1 No. dwelling. This application affects the setting of a Listed Building.
Land adj to 2 North Bersted Street Bognor Regis

Thank you for your internet comments made on 10th February 2017 which has been recorded as **'an objection'** with the comments as follows:

Project
NORTHERSTEDSTREET
BOGNORREGIS
Drawing
ELEVATIONS&SECTION
Date
NOVEMBER2016
Drawn by
TK
Status
PLANNING
Scales
1:100@A1
Job No
TSP573
Dwg No
PL-03
Revision

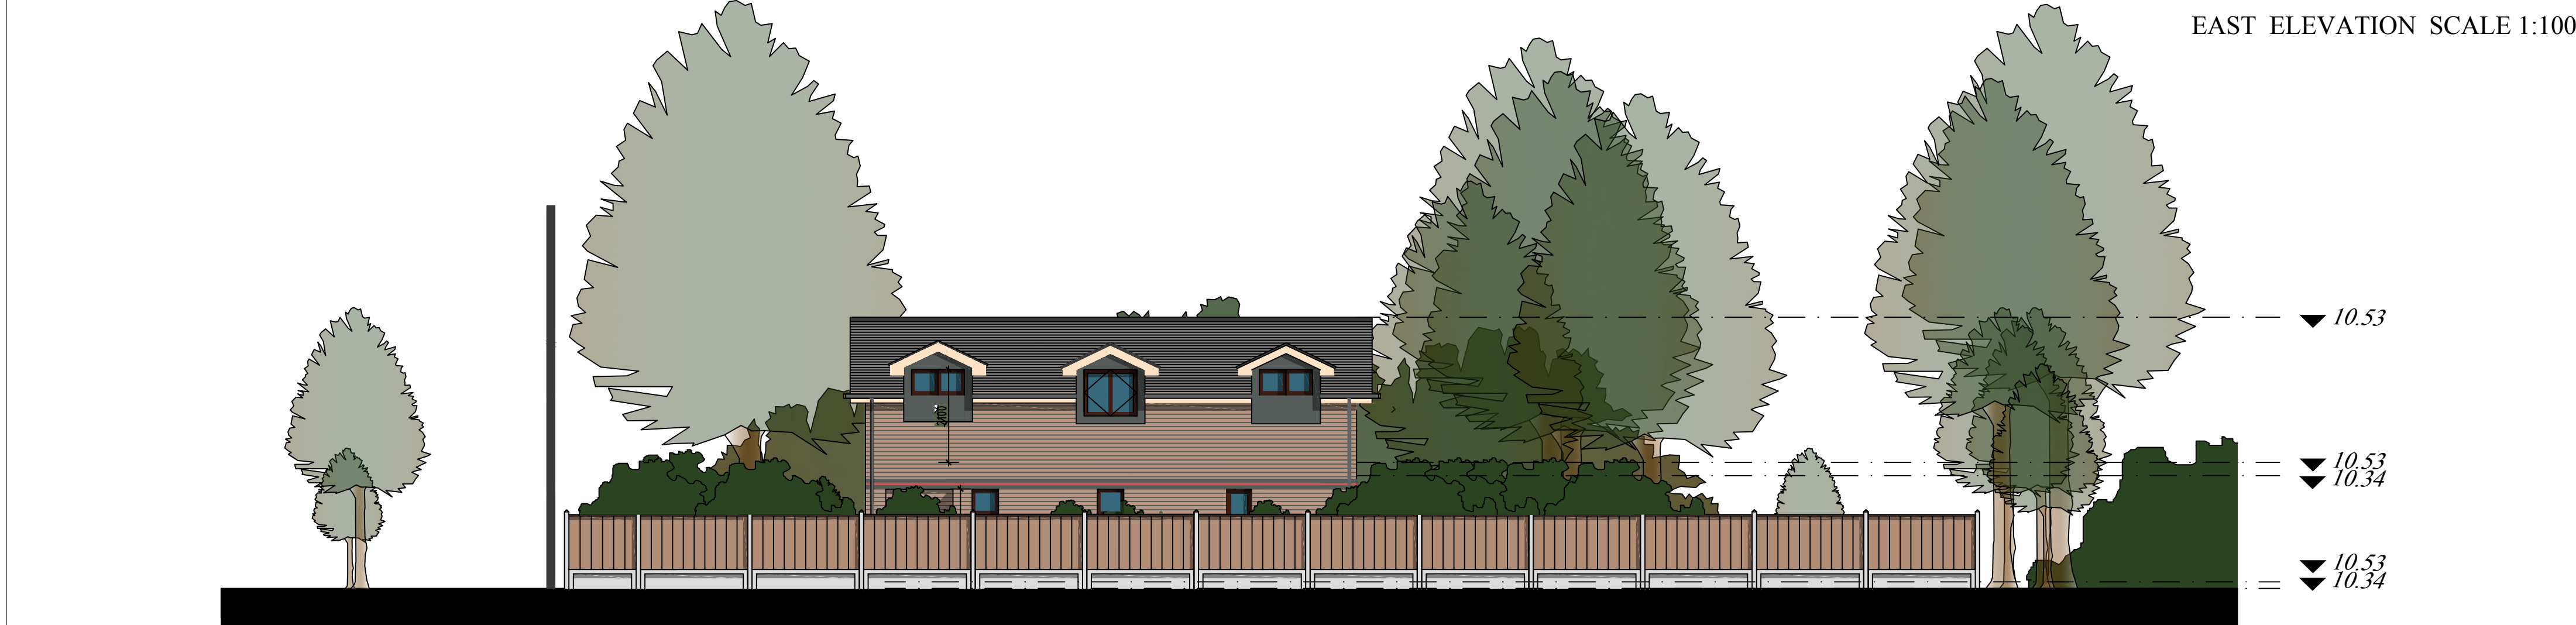
The application does not comply with Bersted Neighbourhood Plan policy ES1 regarding the design of the of the building which will affect the character of the surrounding area.

The application does not comply with ES5 as it does not contribute to the historic character of that area and affects the setting of a listed building
